**Lead Local Flood Authority**  
**Post Point CHN 215**  
**Hertfordshire County Council**  
**County Hall, Pegs Lane**  
**HERTFORD SG13 8DN**  
**www.hertfordshire.gov.uk**

Date 7 February 2024

**RE: 6/2022/1355/MAJ - Former Beales Hotel Comet Way Hatfield AL10 9NG**

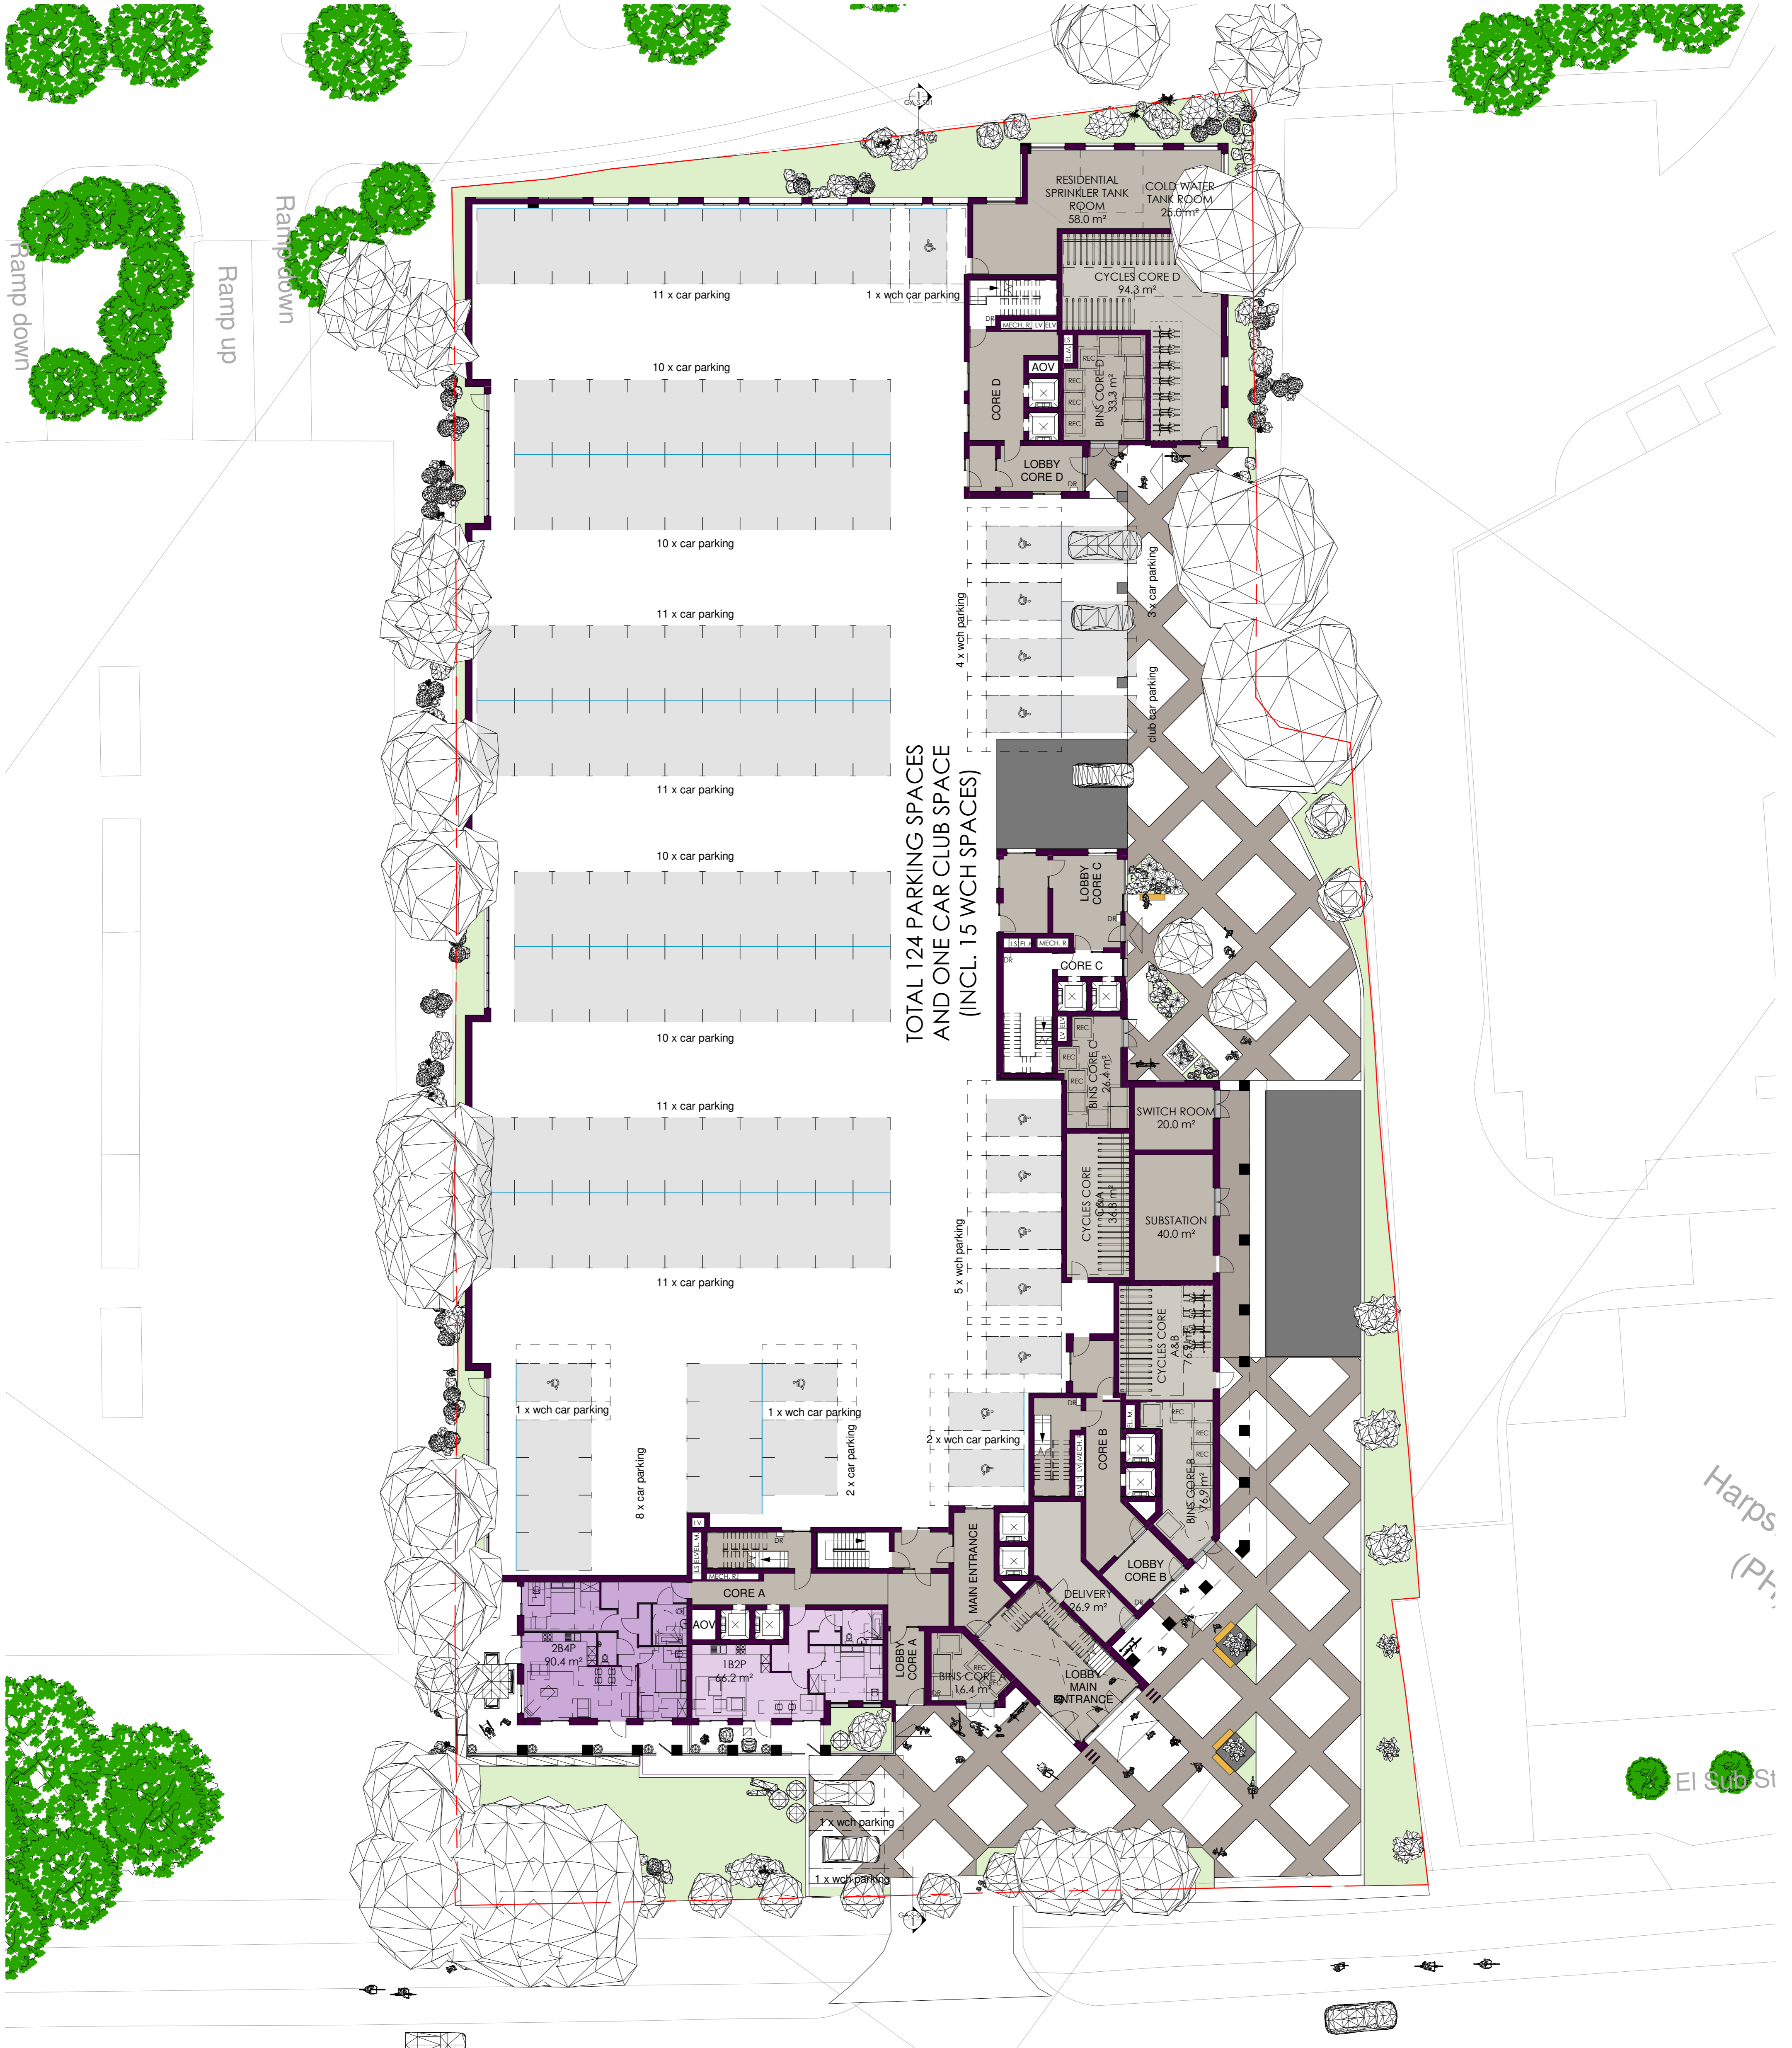
From the drawing submitted (Proposed Ground Floor Plan – Rev PL02 dated 19 January 2024 by ACA Studios), an additional 2 car parking spaces have been added. All of the car parking area is proposed to be permeable paving and we assume that the hatching on this plan also indicates this (however, there is no key). We advise that this is clarified with the applicant. If the car parking is permeable paving then the calculated subbase can be extended to this area without impacting on the risk of flooding to the development.
